April 12, 2019

Re: McCune Ranch Subdivision, City of Colorado Springs, Preliminary Drainage Report Review

On behalf of Winsome Subdivision and its design team, The Vertex Companies, Inc. (VERTEX) is pleased to present the second submittal of the above referenced documents for the proposed residential development at the property located at 17480 Meridian Road North to El Paso County for review. The accompanying documents have been revised to address the County's comments from the recent review of this project. A summary of the actions taken in response to the County's concerns is listed below:

PRELIMINARY PLAN SET WINSOME SUBDIVISION

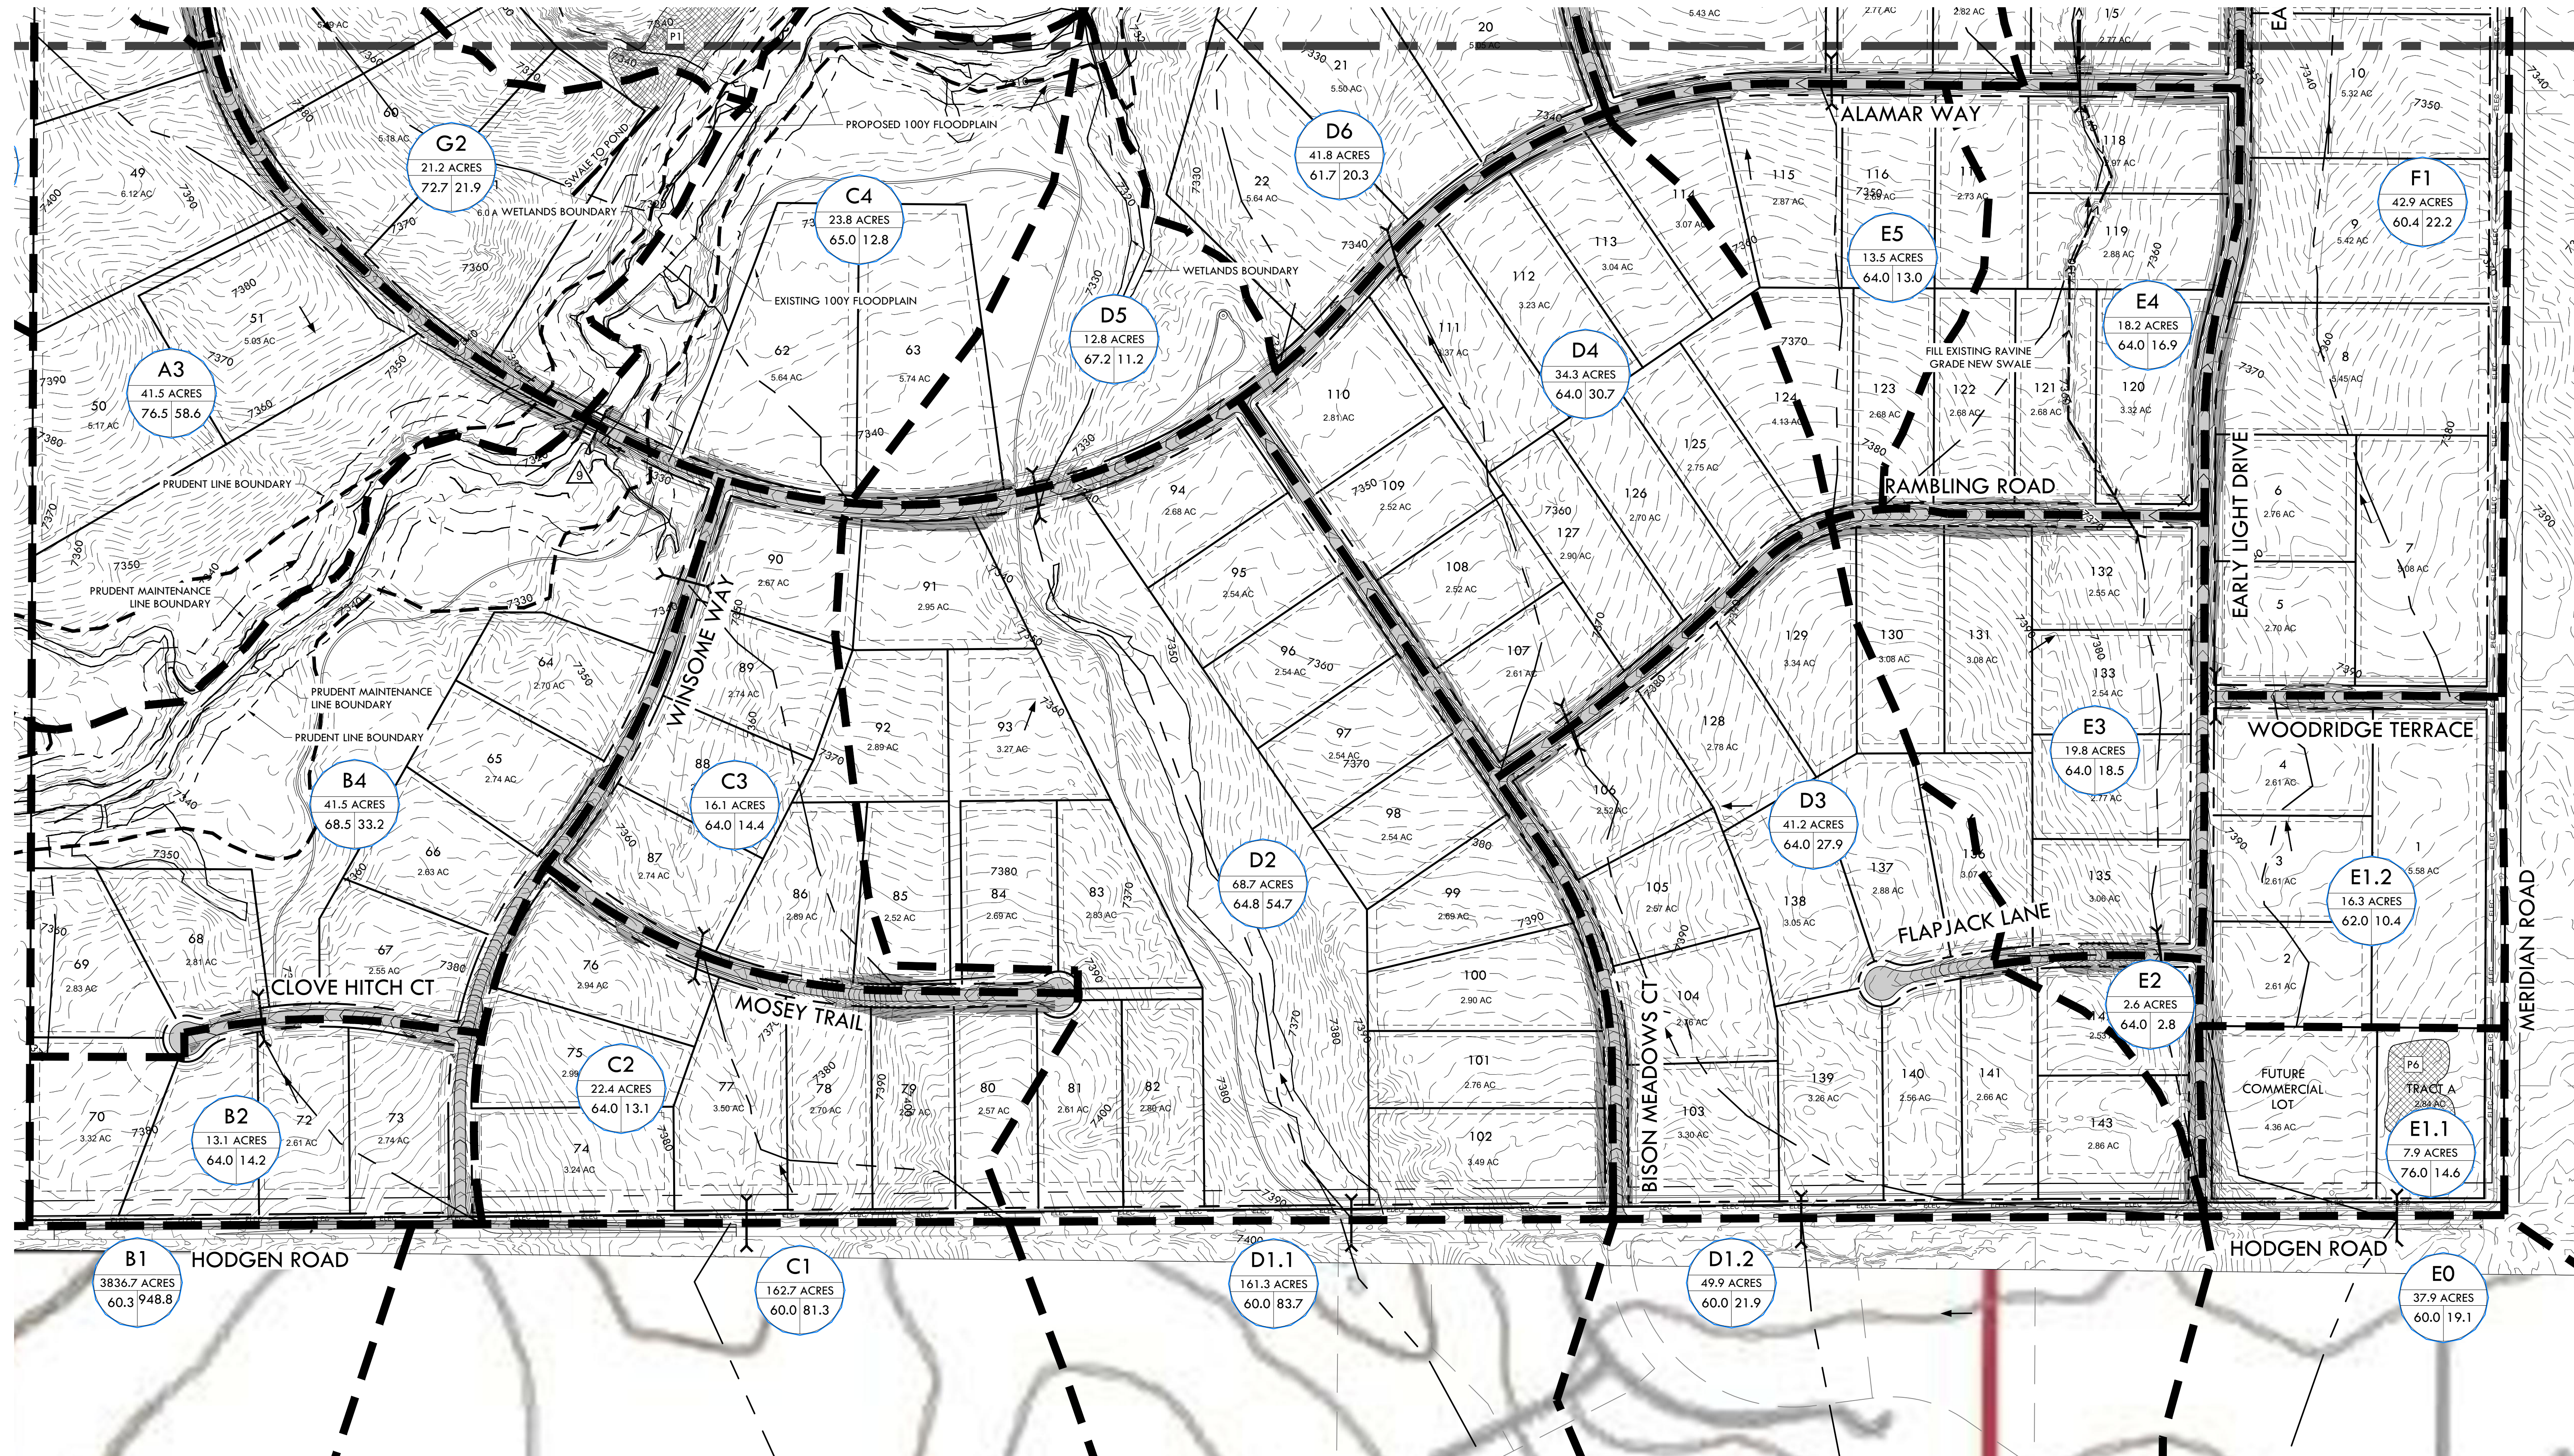
- 11) A basin label has been added to basin G1 on the proposed drainage plan per county comments.
- 12) There was a comment regarding the flow exiting the site (proposed condition) at basin H9 (design point 5). There are multiple basins being routed to this location so the implication is that the flows would be above historic levels. However, all the flows are being routed through Pond 4 and the outfall is regulated to a Q100 of 30.6CFS, lower than the 62.0CFS historic.
